CITY OF ALBUQUERQUE

Re: Albuquerque Studios Master Plan Development
Traffic Impact Study received 1/12/2022
Report date January 4, 2022, HT#R16DA3006A
Engineer's Stamp 1/3/2022

The subject Traffic Impact Study received on January 12, 2022, has been reviewed by the City. The following comments are to be addressed satisfactorily before final approval by the City of Albuquerque Planning Development Transportation Section.

Figure 17 summarizes the recommendations for traffic control and lane configurations for the Implementation (Buildout) Year.

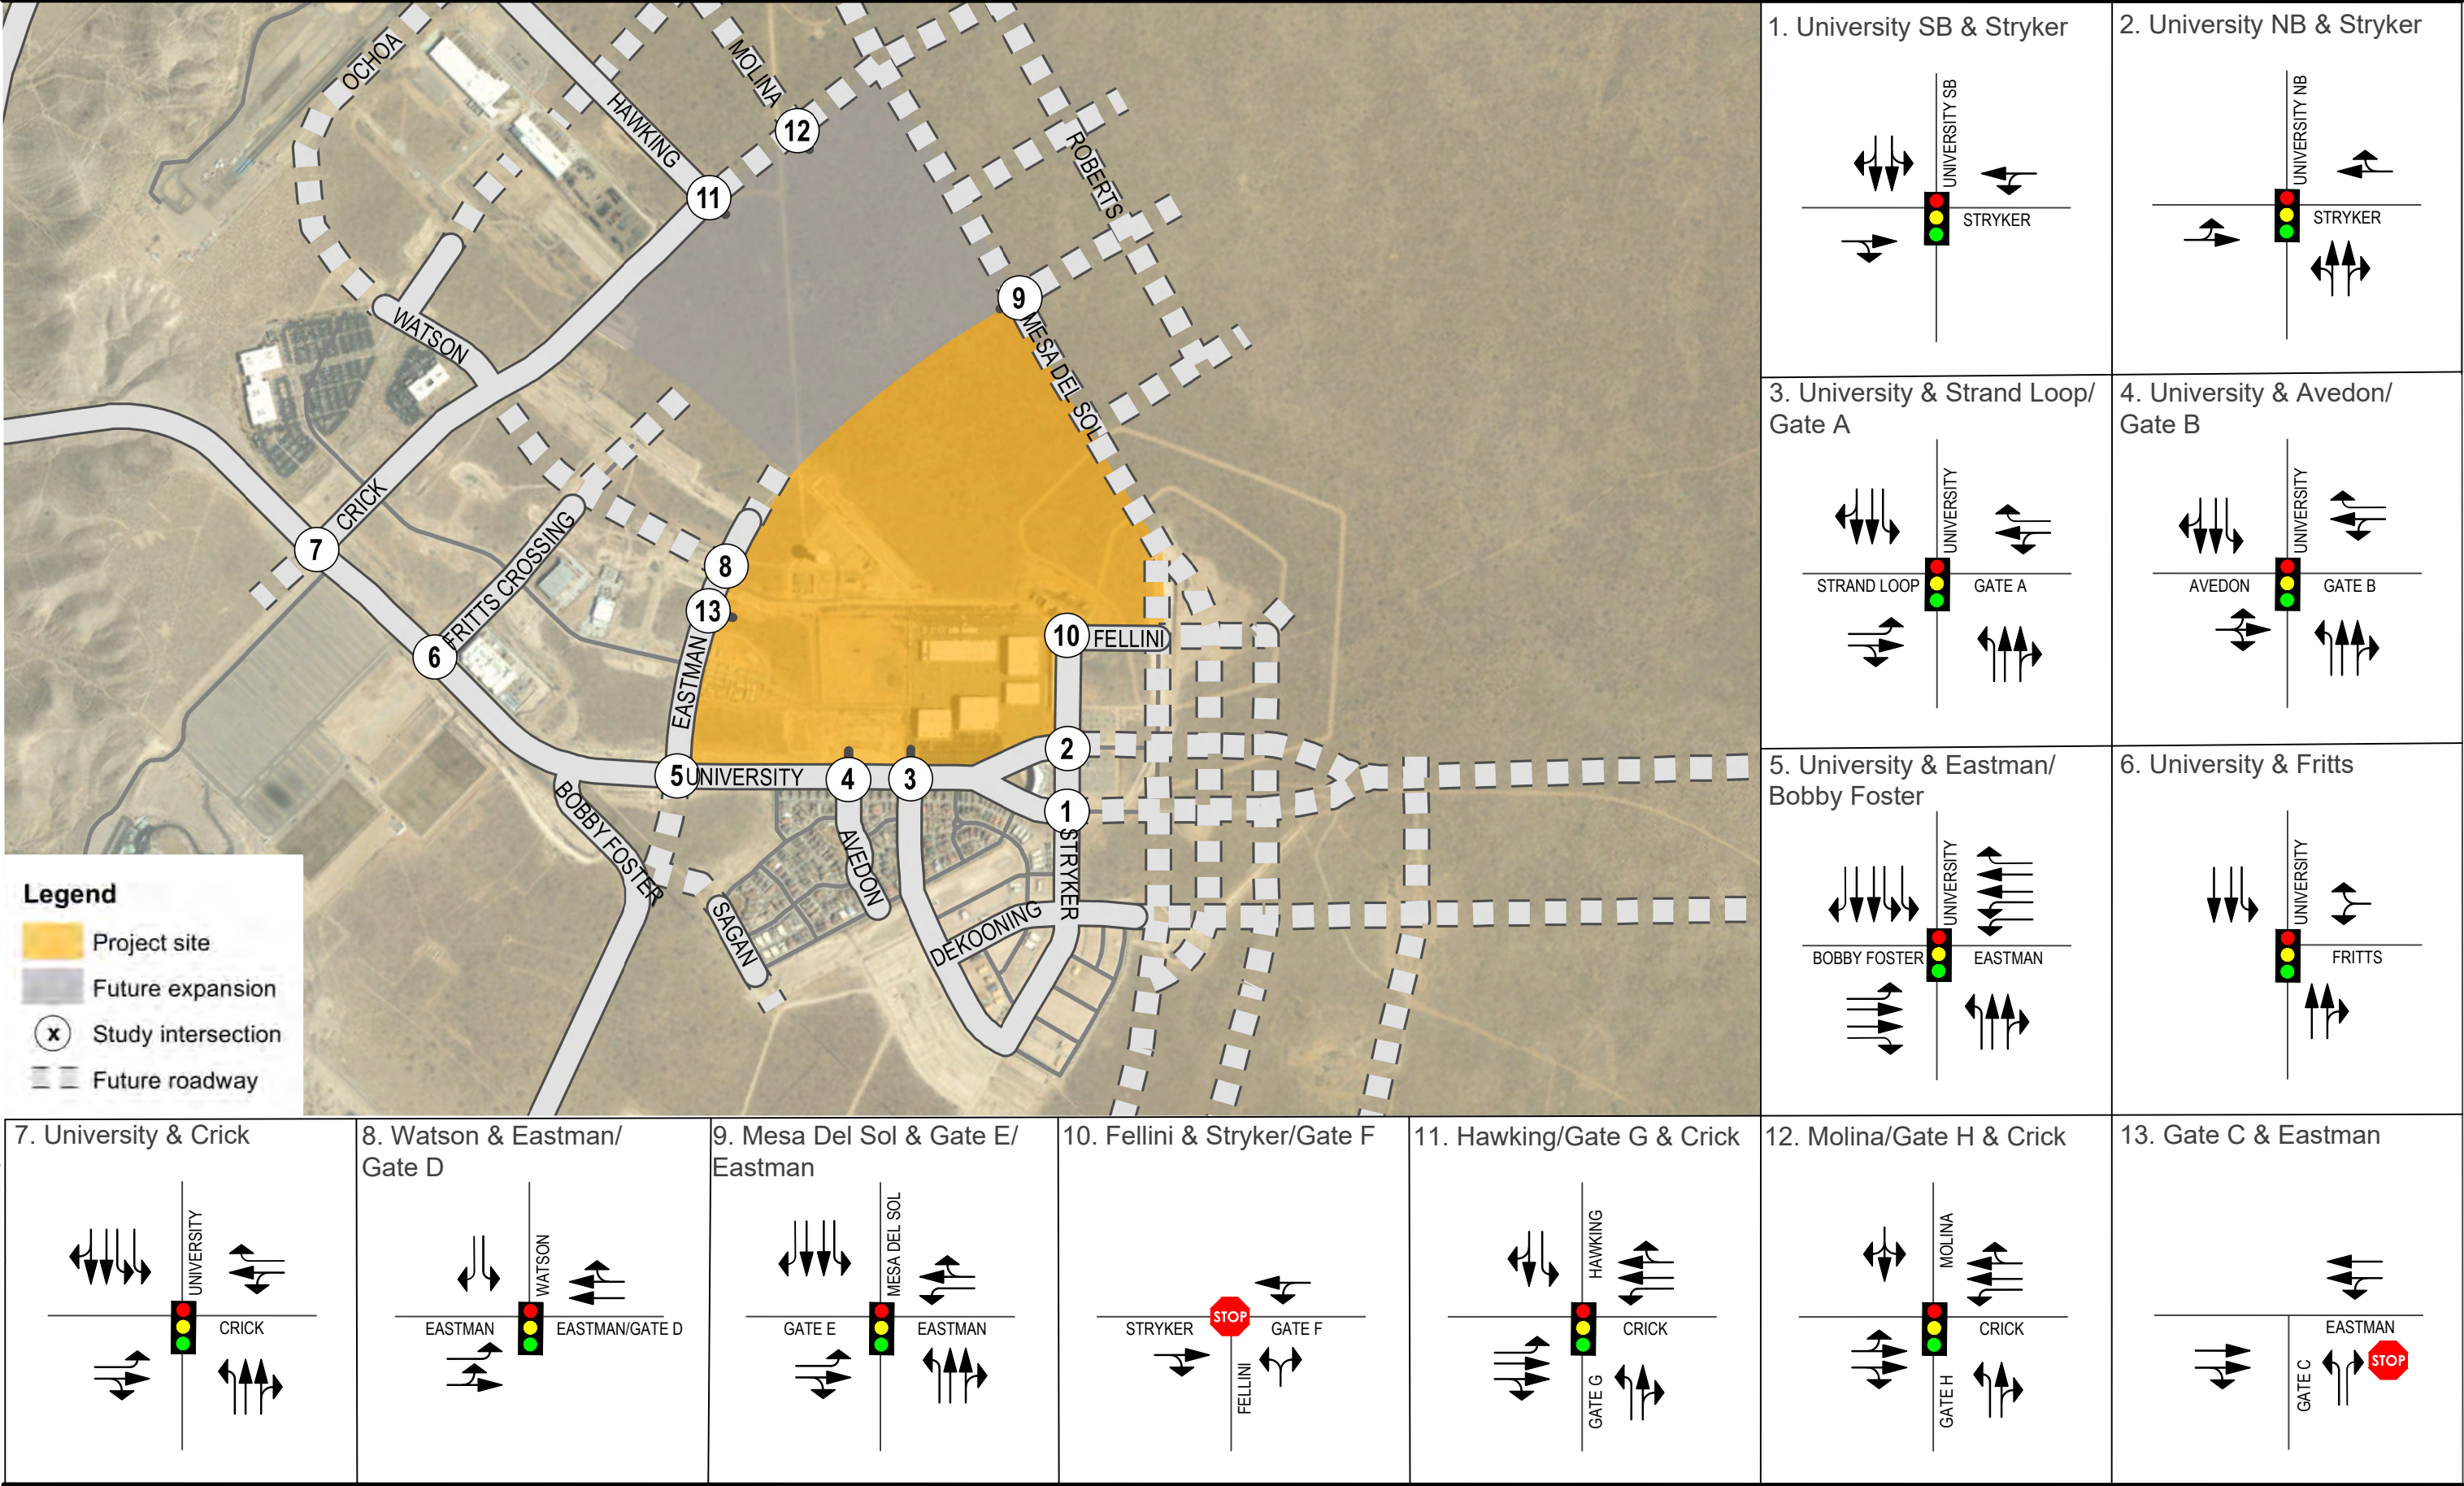
In the Future Intersection Buildout with Project discussion make the following corrections to correlate with the recommendations in the earlier phase "Year 2026 With Project".

- Intersection 2; westbound right-turn lane to be constructed in the in Year 2026 With Project phase.
- Intersection 10; Stryker EB right to SB Fellini – to incorporate a left turn lane. Fellini NB left to Stryker - (Netflix Traffic) – to incorporate a right-turn lane.

The City agrees with the recommendations and results of the analysis. Ensure that all sections of the TIS are consistent with the recommendations. Resubmit the report for final approval by the City.
